HIGH ACRES FARM  
GREAT BOURTON  
BANBURY  
OXON OX17 1RL

25th August 2020

RE: APPLICATION 20/02060/F  
PROPOSED GYPSY CARAVAN SITE  
MAIN STREET GREAT BOURTON

# SITE LAYOUT PLAN

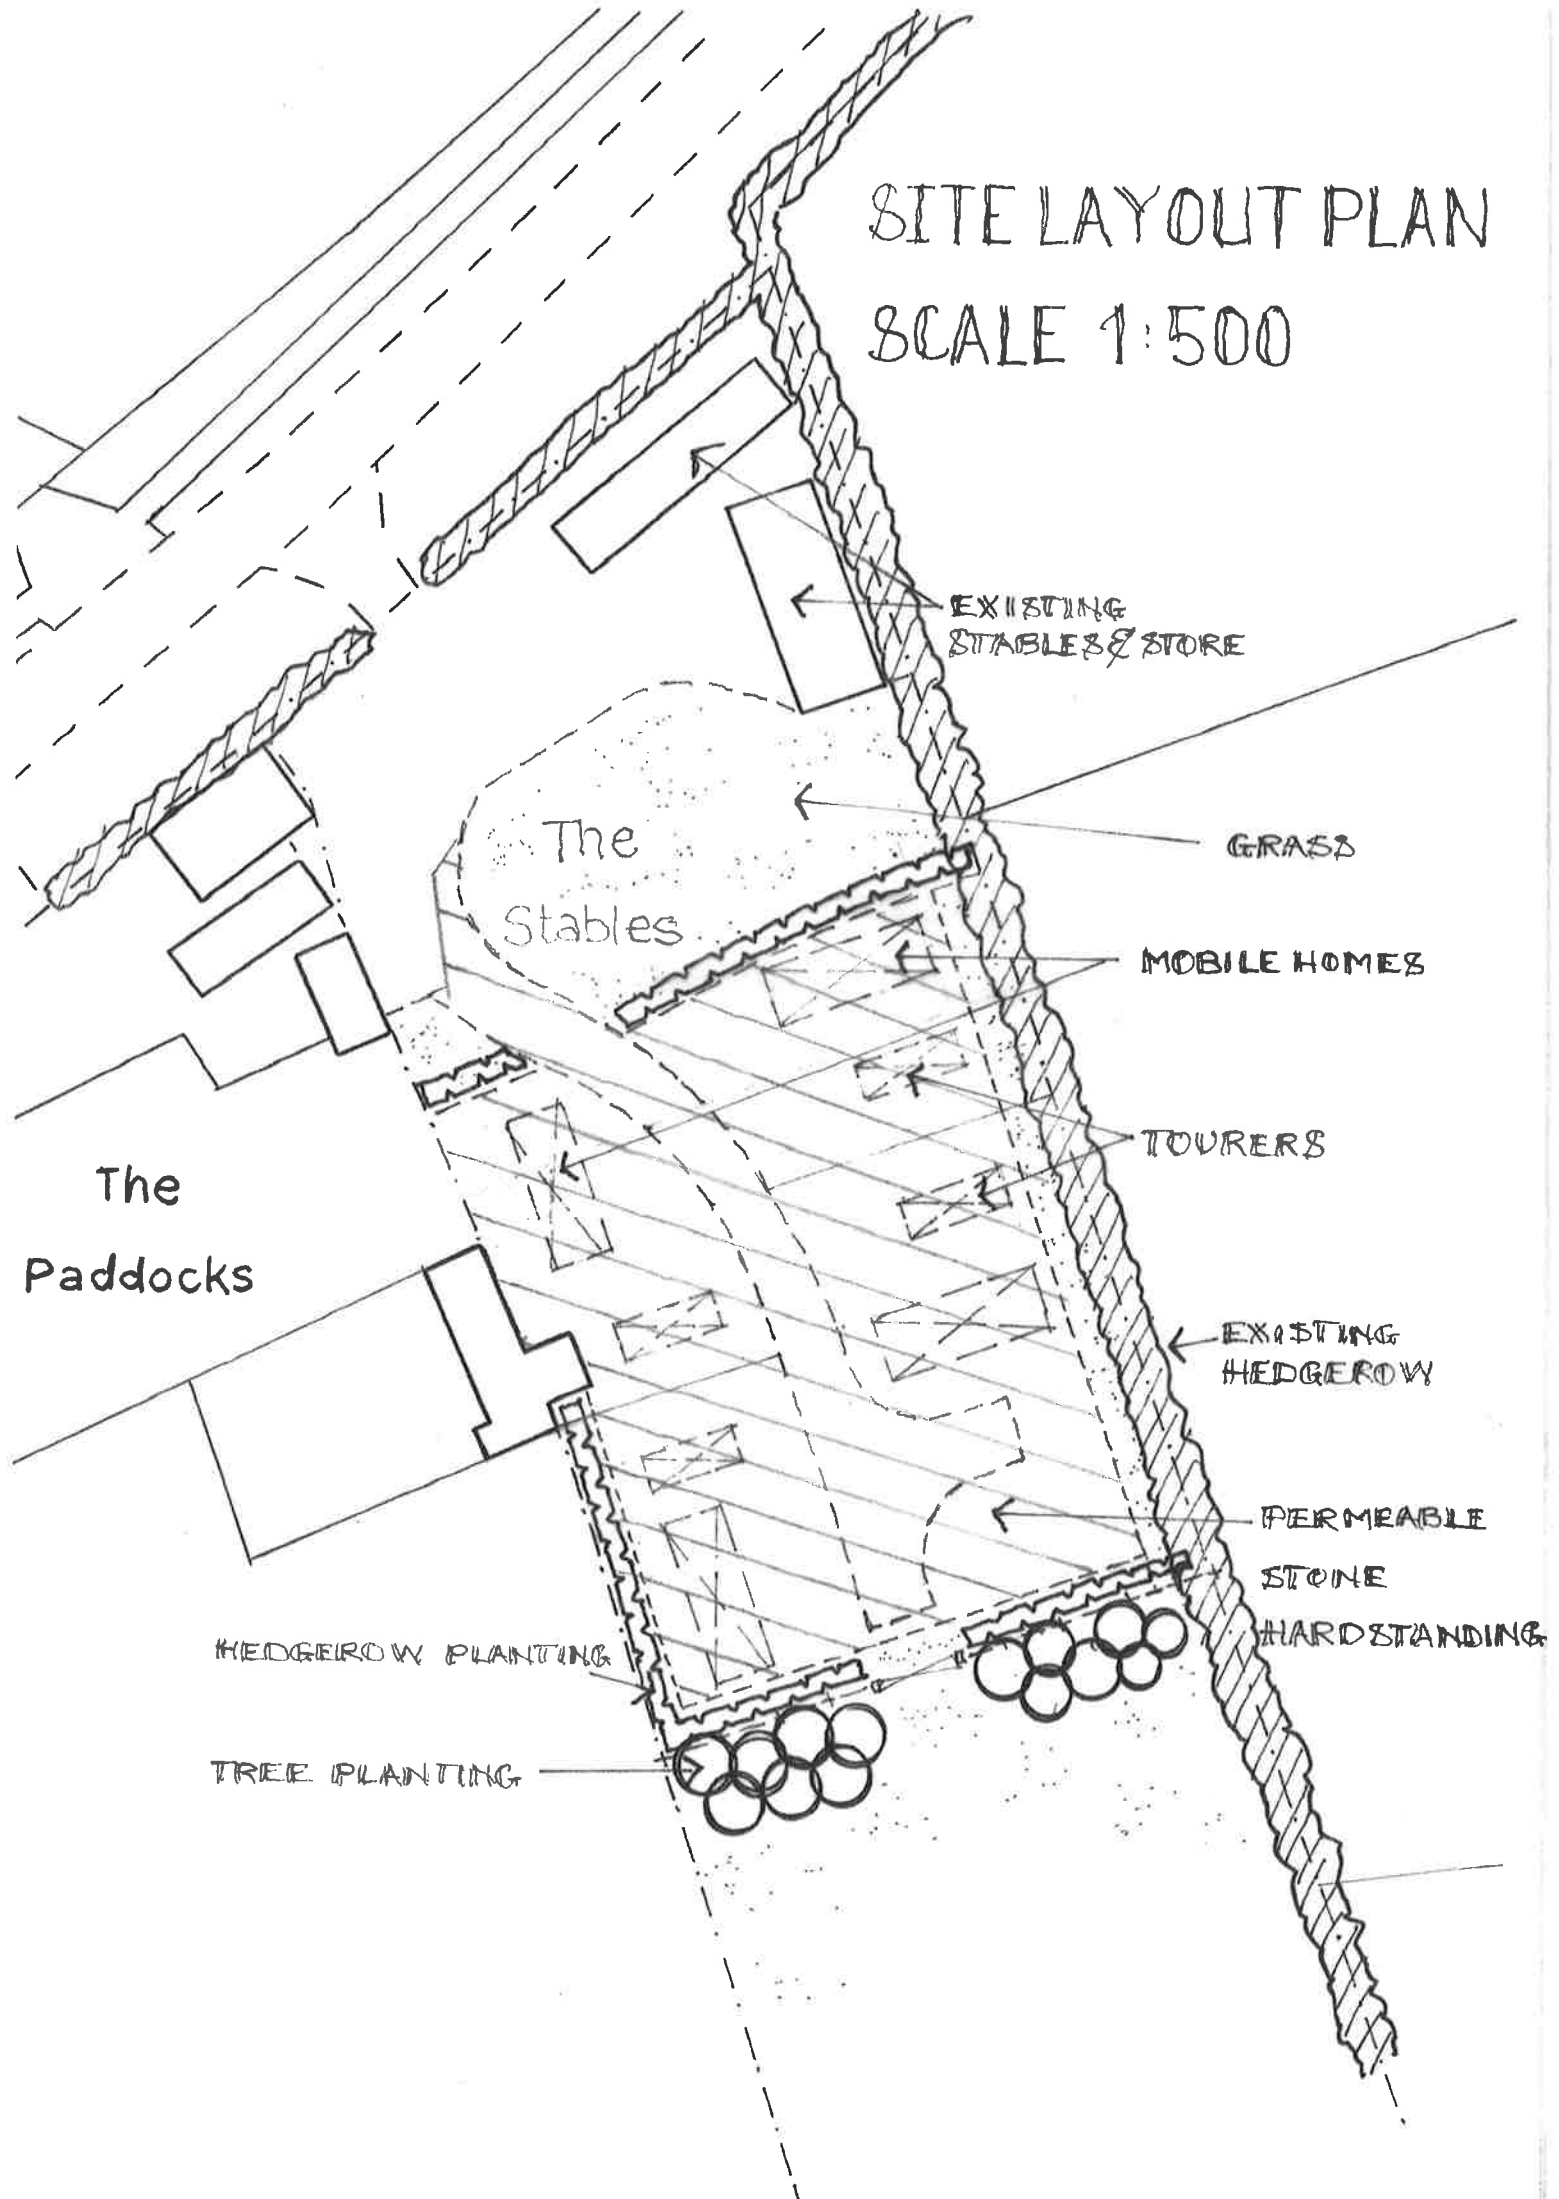
I was involved with land drainage, installing around 100 miles of farm land drainage schemes annually. It is proposed to treat to sewage on site and also put in soakaways but this will never work on such low lying impermeable land and it would be inevitable that foul water would flow through the grounds of Cropredy School and into the canal. This should never be approved when it could put the health of young children and others at risk.

The agent claims that the proposal is not overlooked by rights of way and yet the footpath from Little Bourton to Cropredy goes diagonally through the site! There have already been problems with dogs on this site challenging walkers and this has been reported to both the Parish Council and the CDC Dog Warden.

The land is designated in the CDC Local Plan as being an area of High Landscape Value and is very visible from the village of Great Bourton. It is far too wet for a Sewage Treatment Plant and any Residential use and if even more hardcore is installed to raise the level of the site it

will be detrimental to adjoining land owned by others including the Parish Charity Poor Land because through displacement they would be more at risk of becoming flooded.  
I believe that if approved this application would be the thin end of the wedge and would lead to an ever increasing caravan development.
